Subject: FW: Application Number EP/52/18/PL Scorton 9 Lime Tree Close East Preston BN16 1JA- Demolition of existing dwelling & the erection of 7No. residential dwellings, with associated parking, amended access location from Lime Tree Close & landscaping

Subject: Application Number EP/52/18/PL Scorton 9 Lime Tree Close East Preston BN16 1JA- Demolition of existing dwelling & the erection of 7No. residential dwellings, with associated parking, amended access location from Lime Tree Close & landscaping

Drawing ref: LT.SC 001

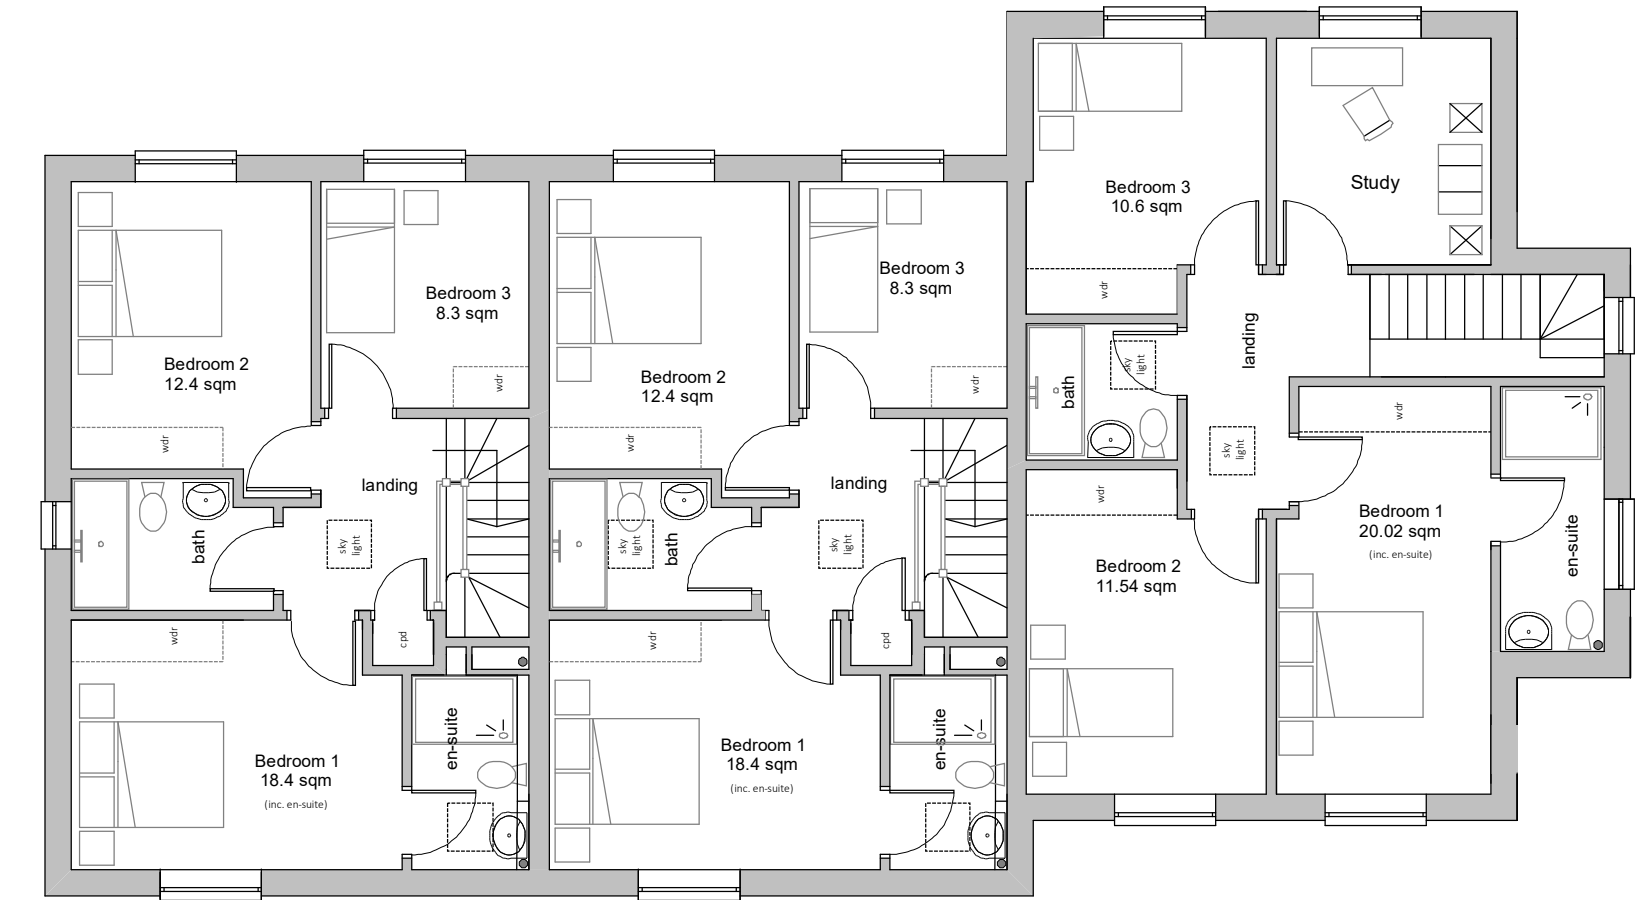
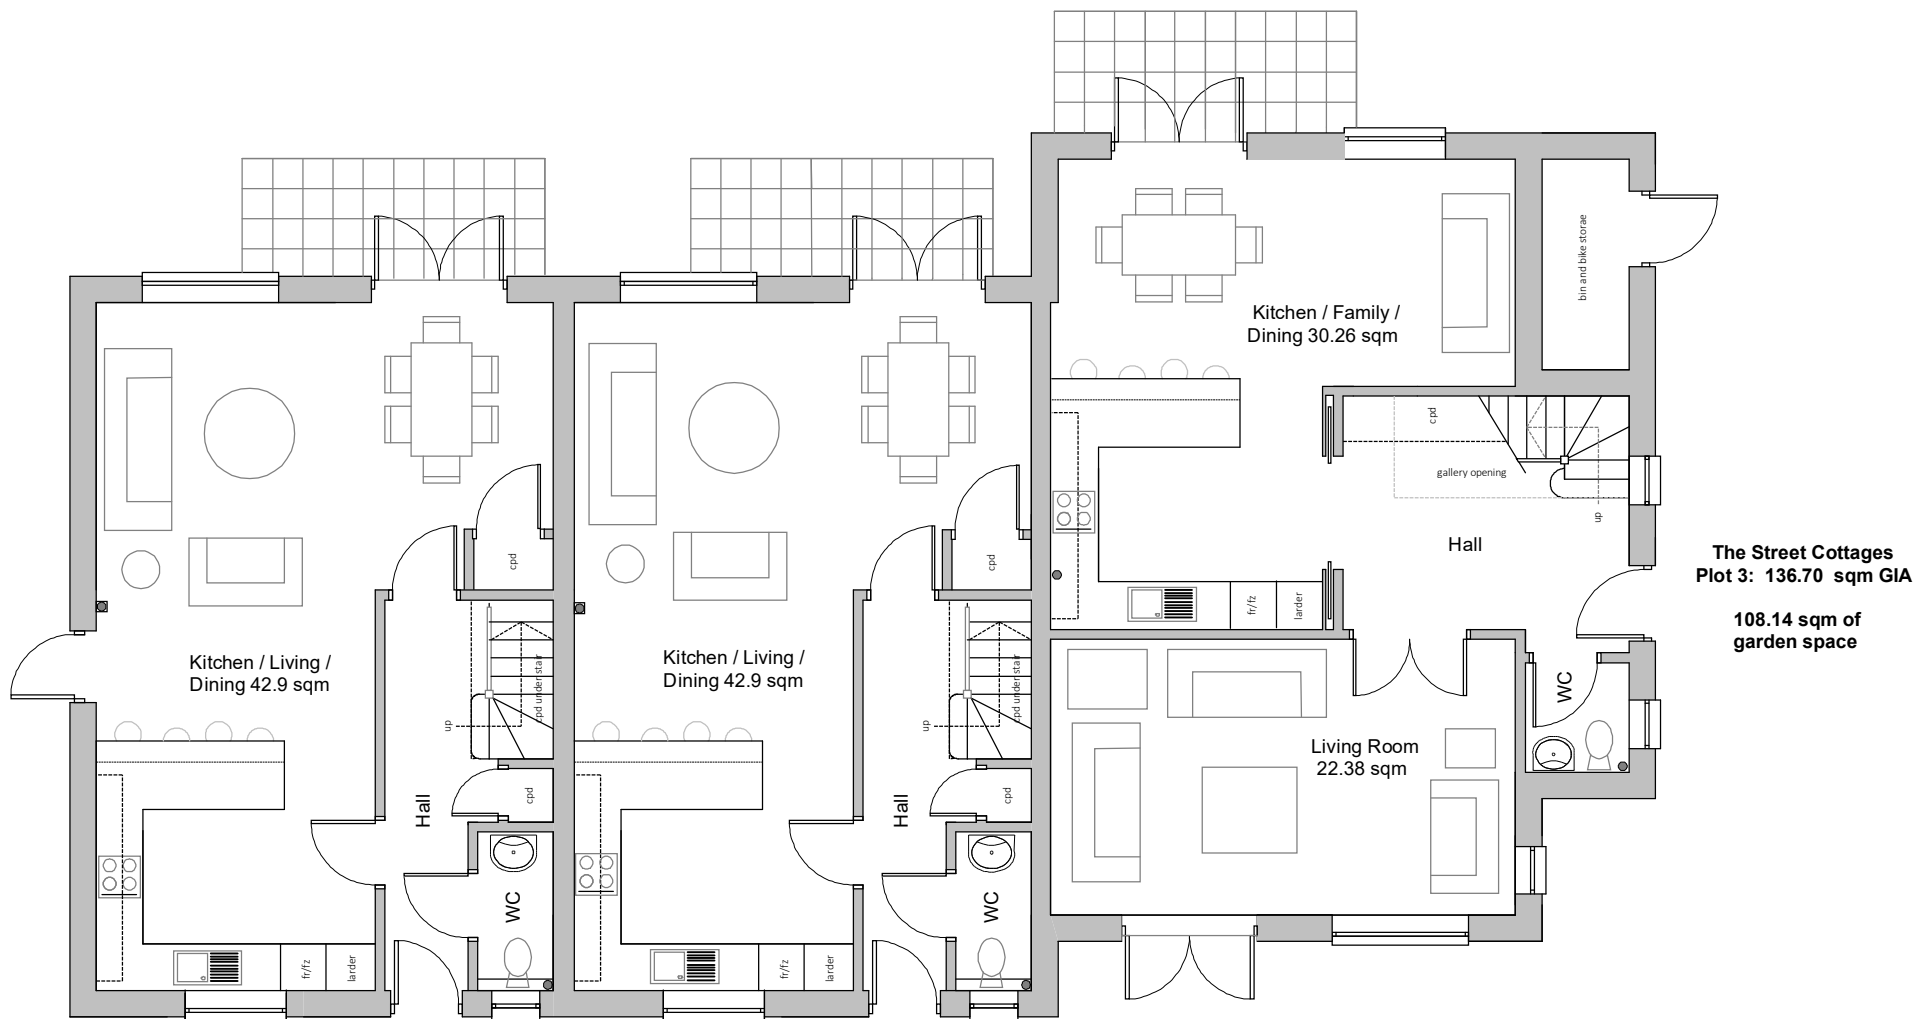
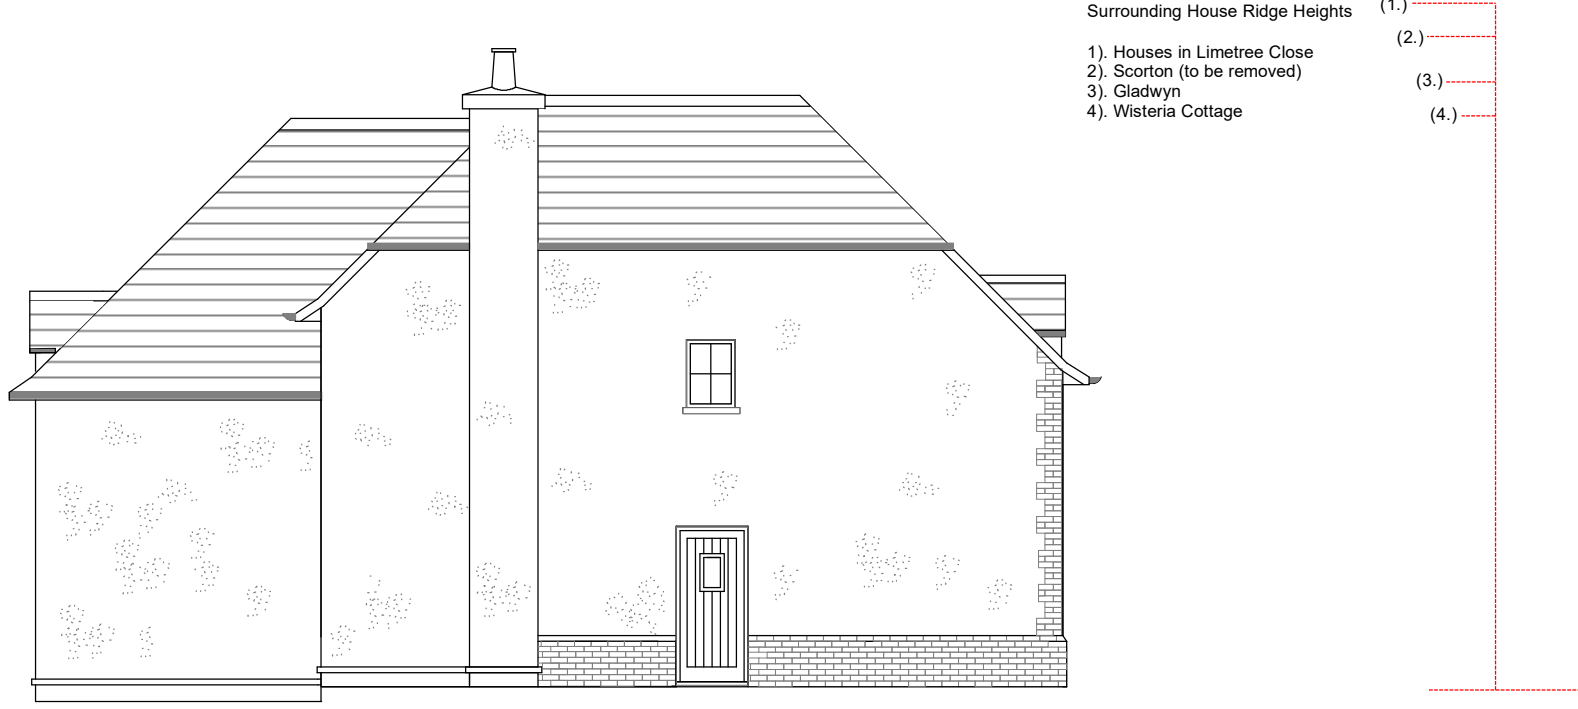
The developers state that the outlook will not be into private amenity space but rather the open garage and parking area of our cottage. This is simply not true. Whilst we do not dispute that the parking area in front of our garage allows an open view to those who pass by our back garden is currently private and not visible to passers by but should the proposed development go ahead there will be direct line of sight from the bedroom 1 of plot 1 into a significant part of our garden and also to a lesser extent from bedroom 1 of plot 2.

TITLE: Swept Paths March 2018 SITE: Limetree Close East Preston	Drawing: Vehicle Swept Paths	Autoturn Vehicle Swept Path Analysis & Visibility Data Prepared by Autoturn Specialists in Simulated Vehicle Swept Paths
	Drawing Reference: LT.SWEPT.001	
	Scale: On A2 1:200 / as bar

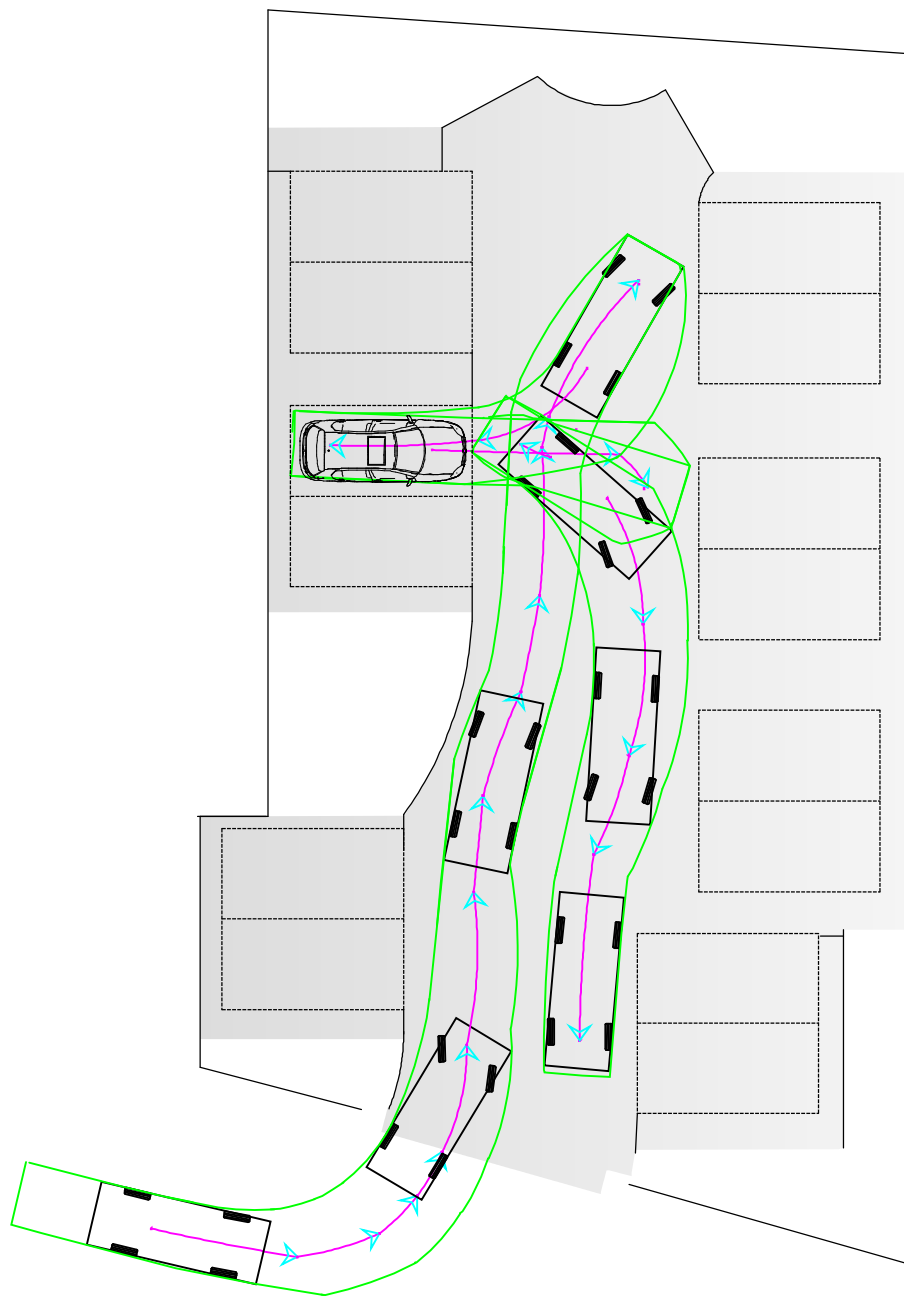
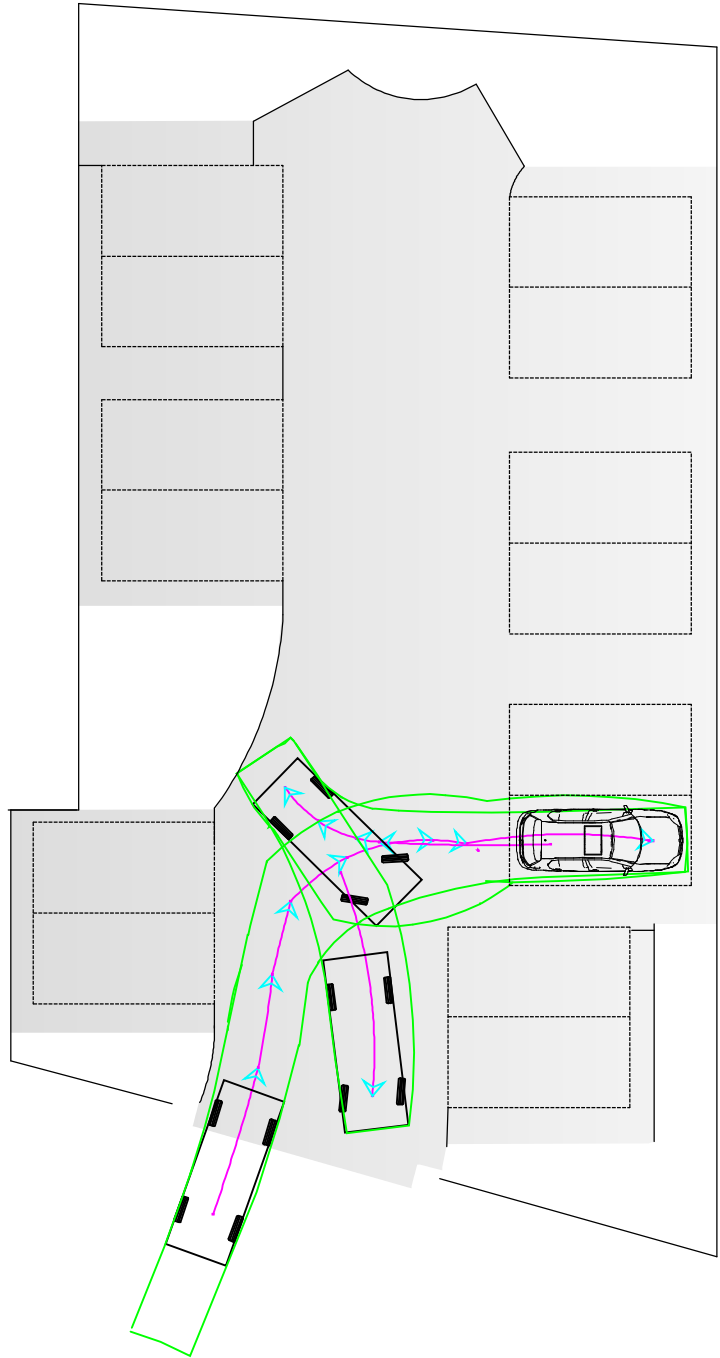
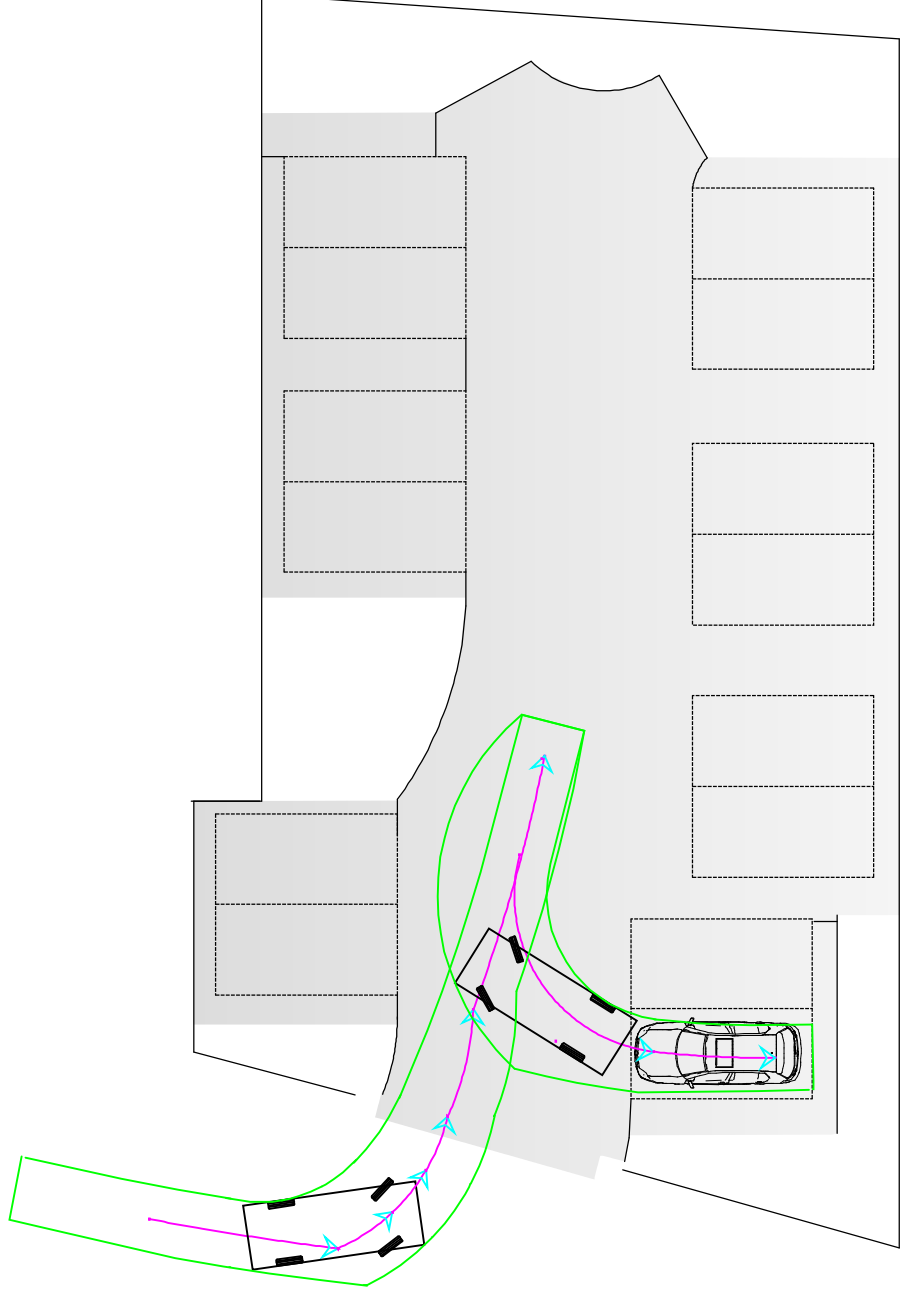
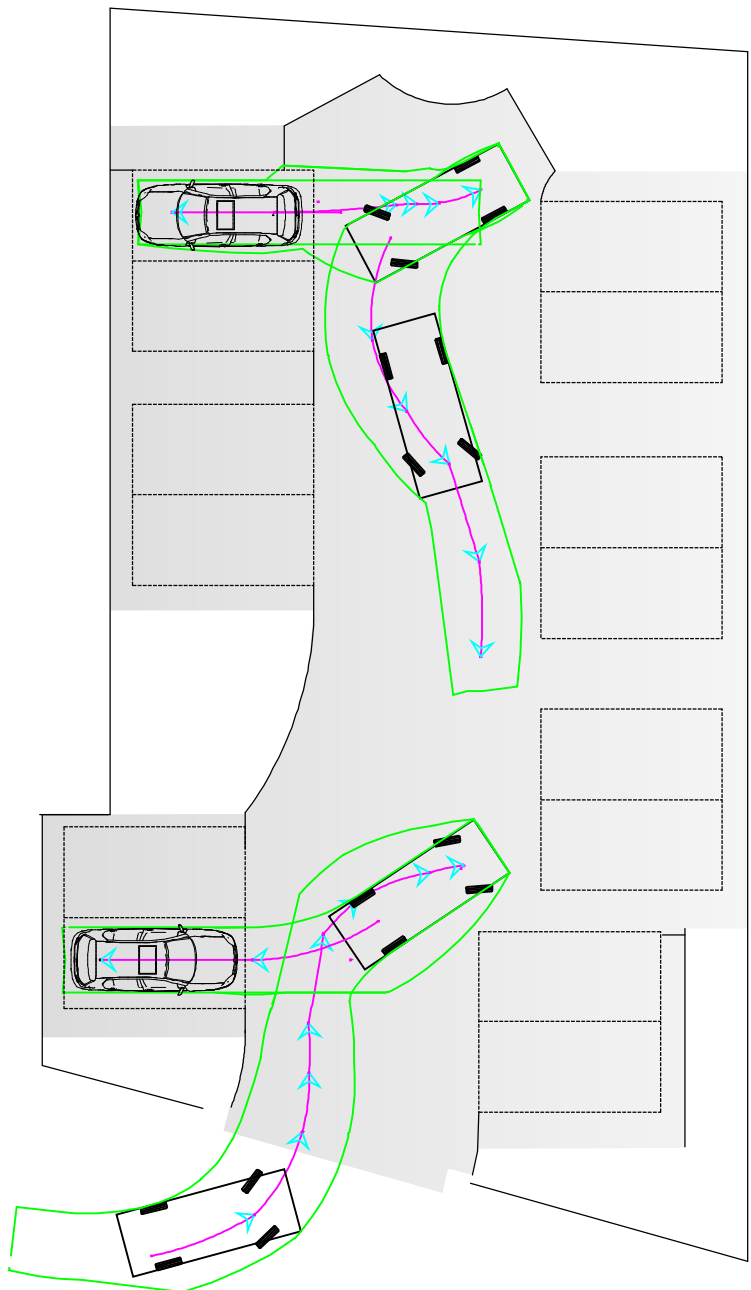
According to the submission from Highways, WSCC their parking demand calculator shows that 16 allocated parking spaces are required for the proposed development yet only 14 spaces have been allocated. The developers have allocated an extra 2 parking spaces by the addition of the lay-by on the north side of Lime Tree Close but as the developers readily admit it is not within their gift to include this lay-by in the development. Firstly the verge to be used for this lay-by does not belong to Scorton and secondly the East Preston Village Design statement guidelines clearly advise that verges in this part of the village be preserved and not turned into parking lay-bys.

Therefore this is an over-development of the site with insufficient parking space and we would object to the construction of the lay-by in accordance with the Village Design Statement guidelines.
